HINCKLEY RAIL FREIGHT TERMINAL

Comments on Written Responses

Sapcote Parish Council

Oct 2023

Proposed Layout - School buses waiting in loading bay in front of Co-Op

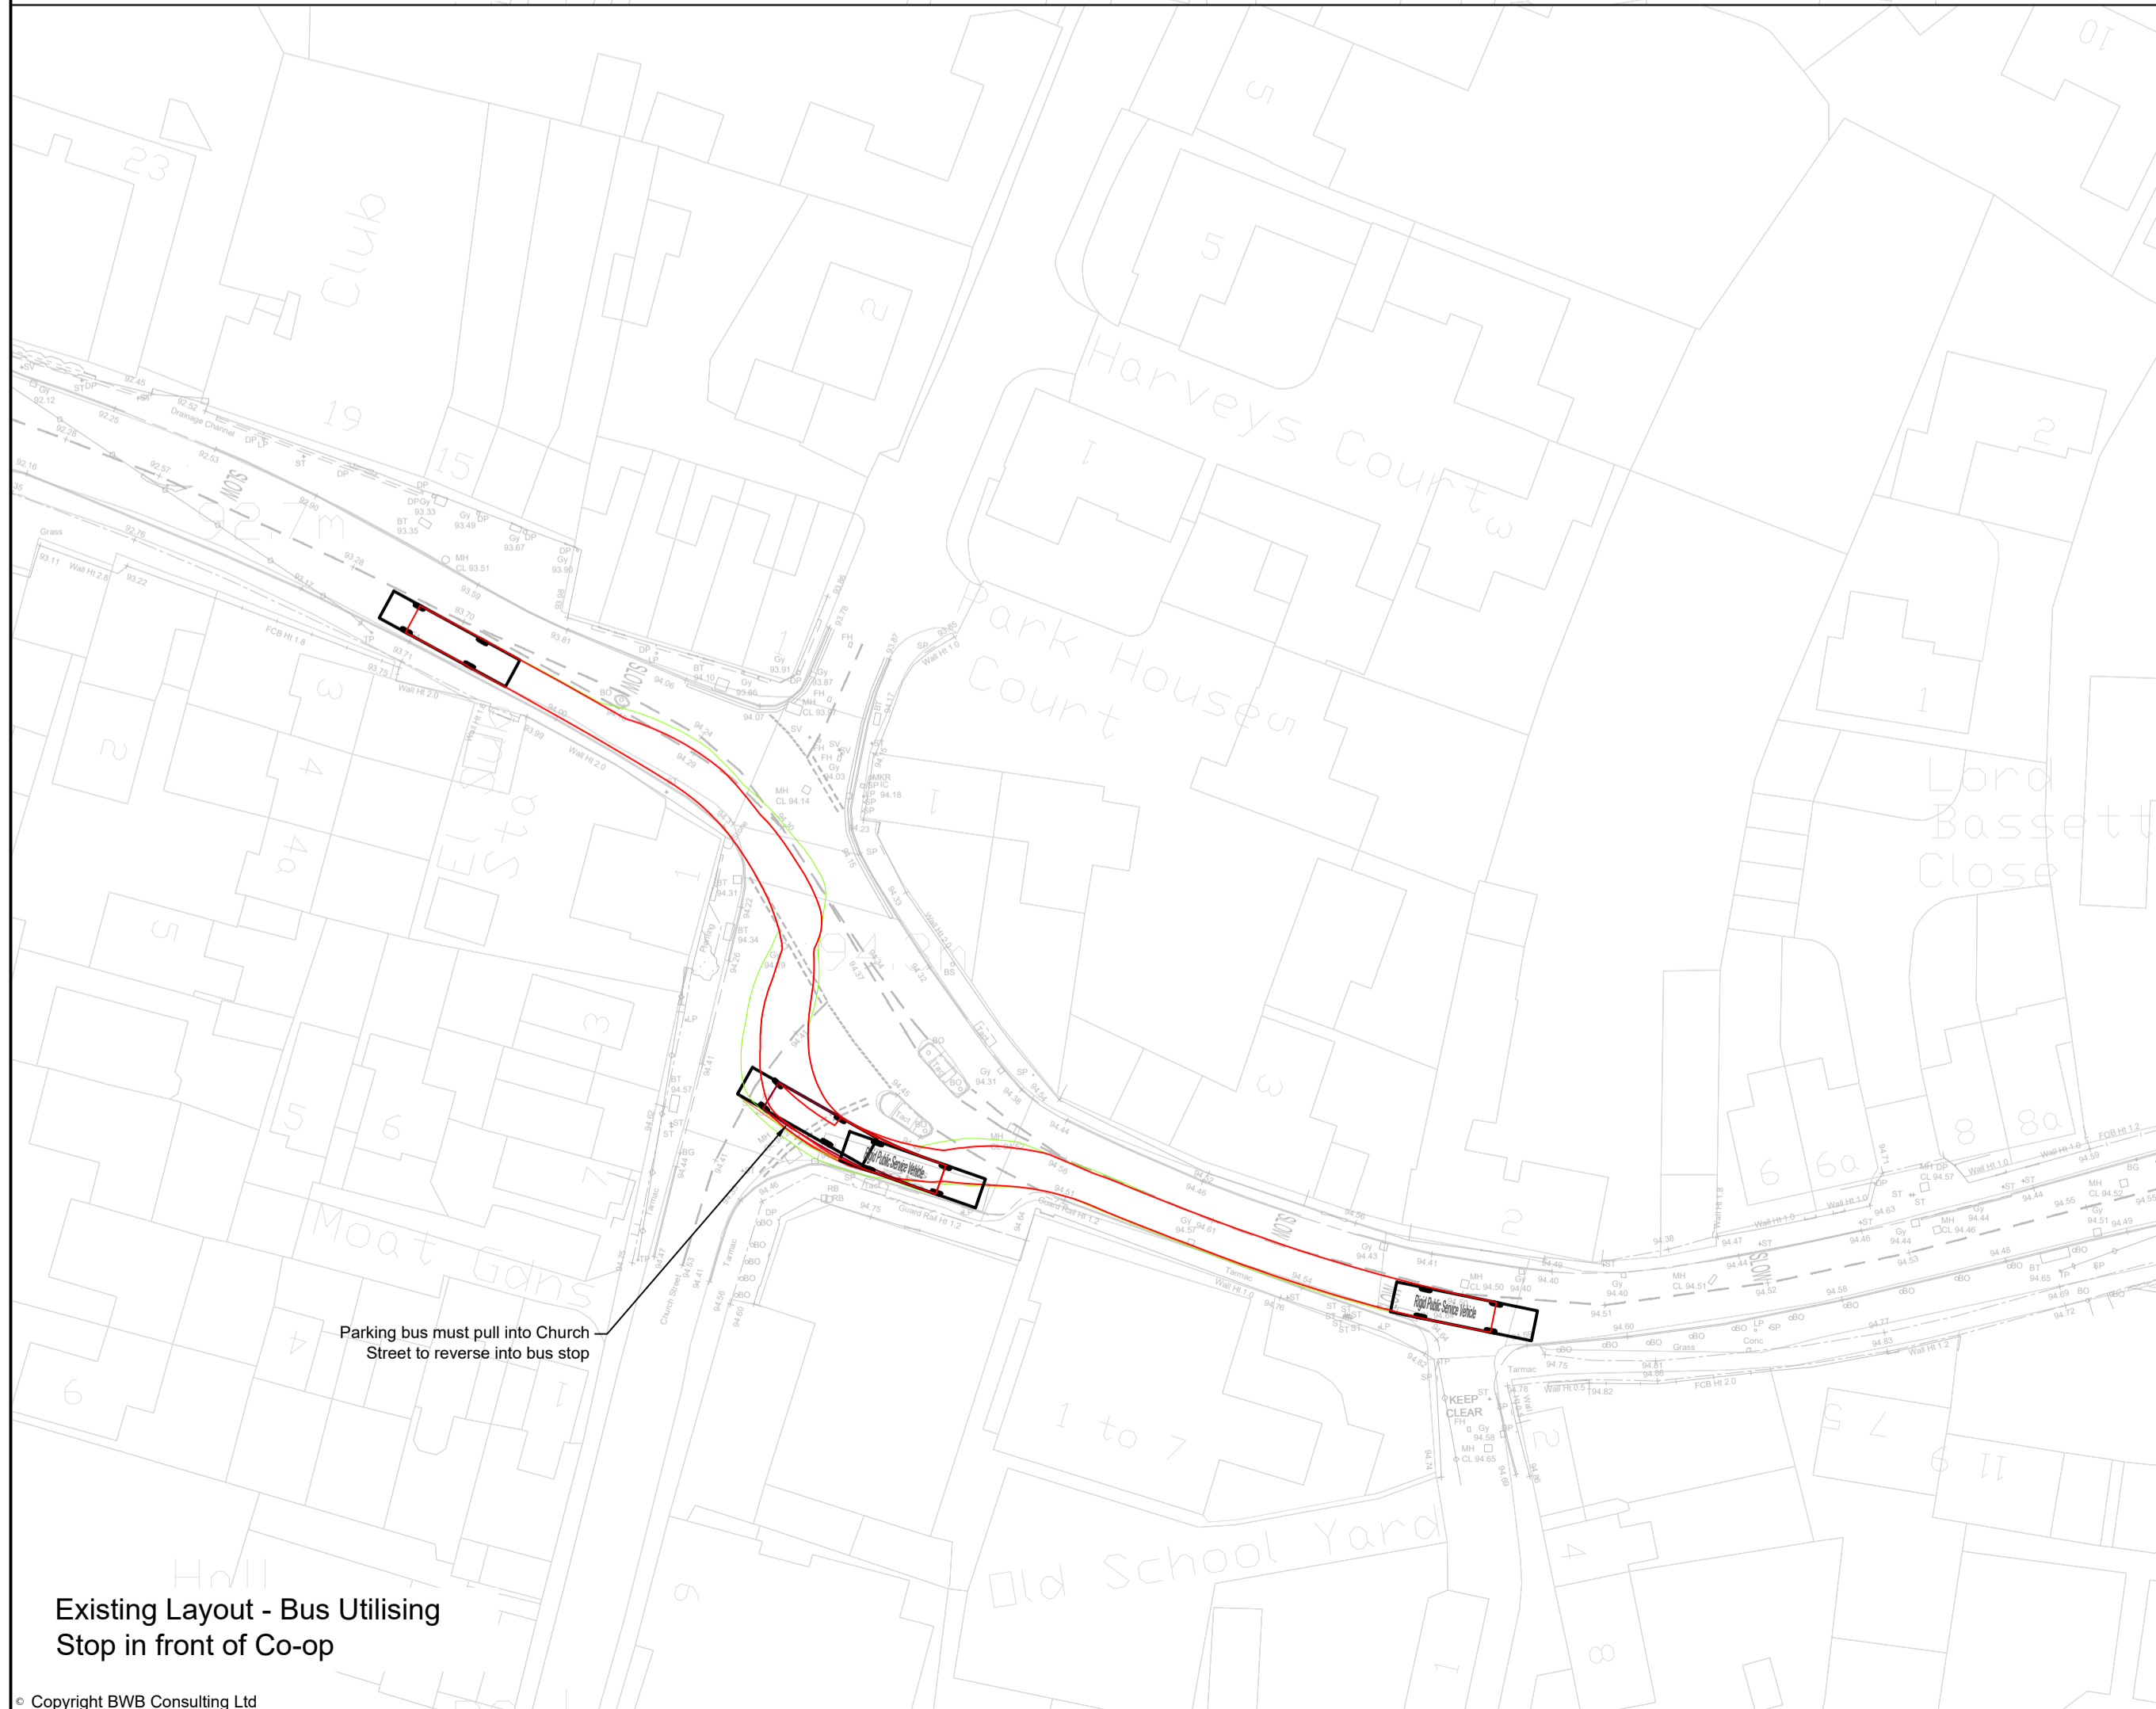
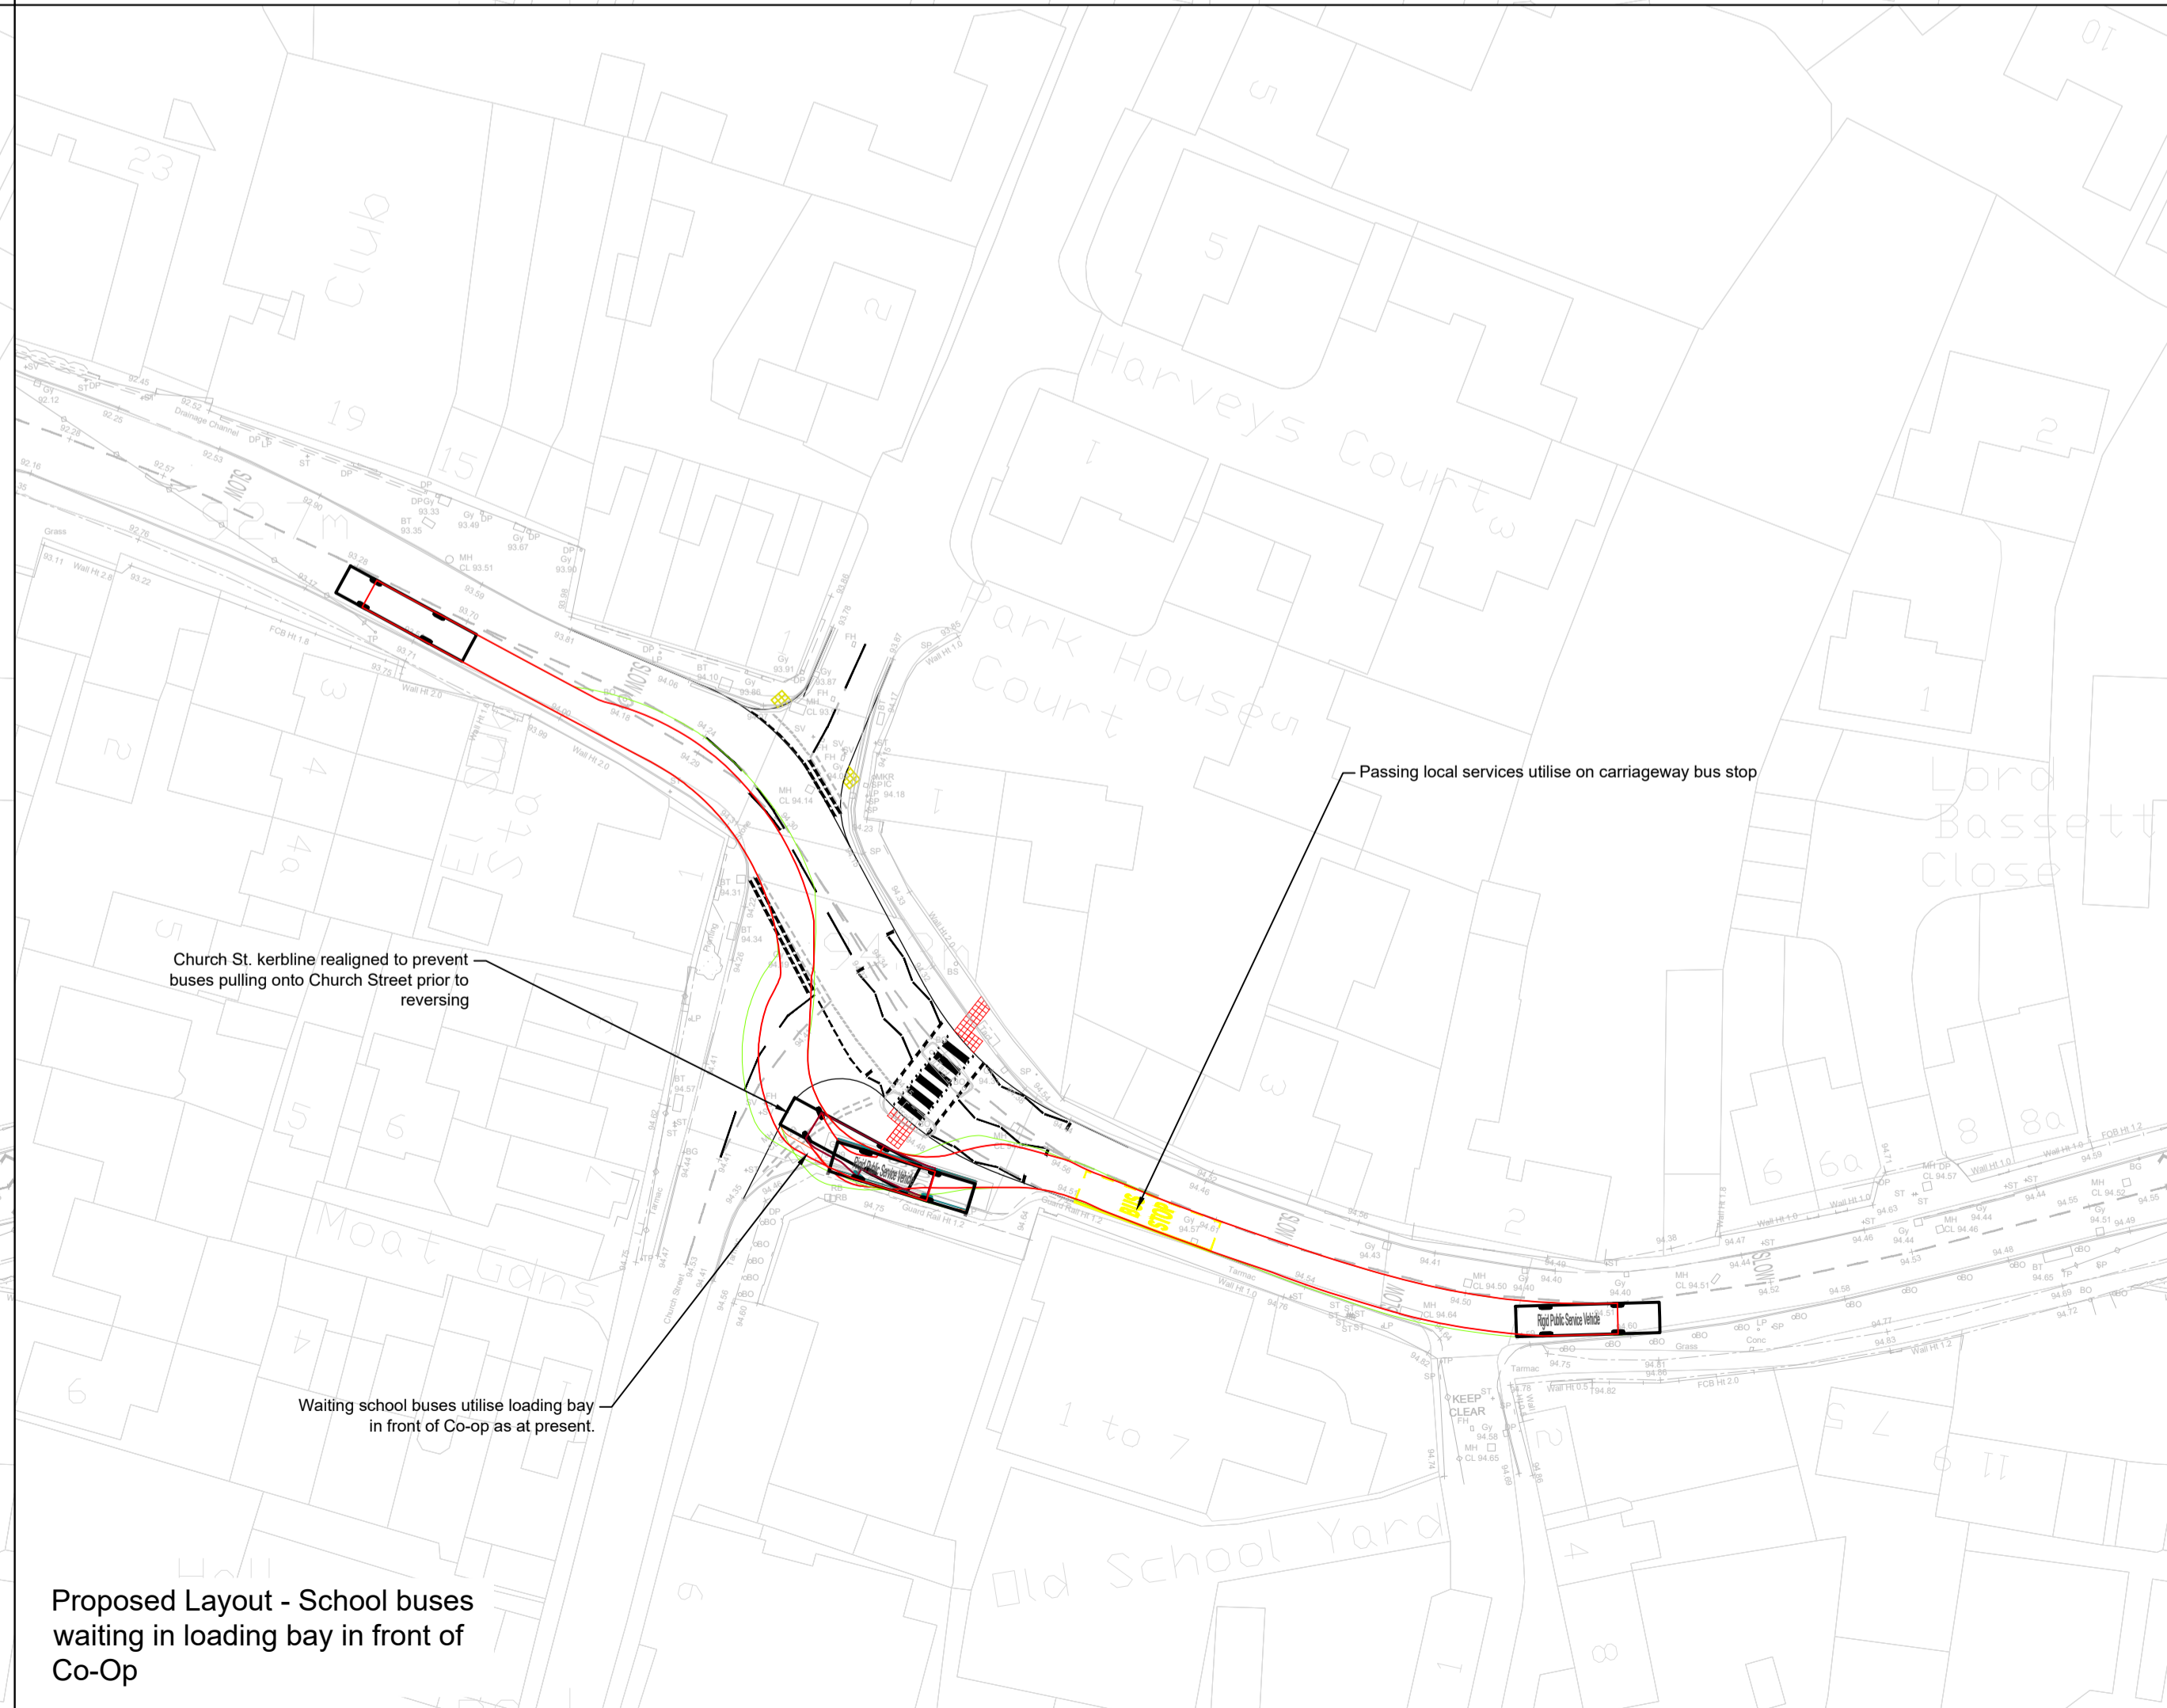
1.15 Moreover, the proposals require the removal of the off-road bus stop outside the Co-Op and its relocation north beyond the narrow section of road and pavement where it may delay traffic.

1.16 This was previously used by the X55 but that was replaced by the Fox Connect who use that layby for pick-ups and drops-off as well as the other bus stops in the village. Under the new regime anyone using that service and wishing to access the centre of the village would have to negotiate the narrowest section when alighting from a bus.

1.17 In addition, all secondary aged children have to travel to local towns for schools. The majority travel by bus to either Broughton Astley/Lutterworth or Burbage/Hinckley. Buses collect children in the morning and drop them off at the end of the day from that bus stop, as this is currently a safe place to access a bus in the centre of the village.
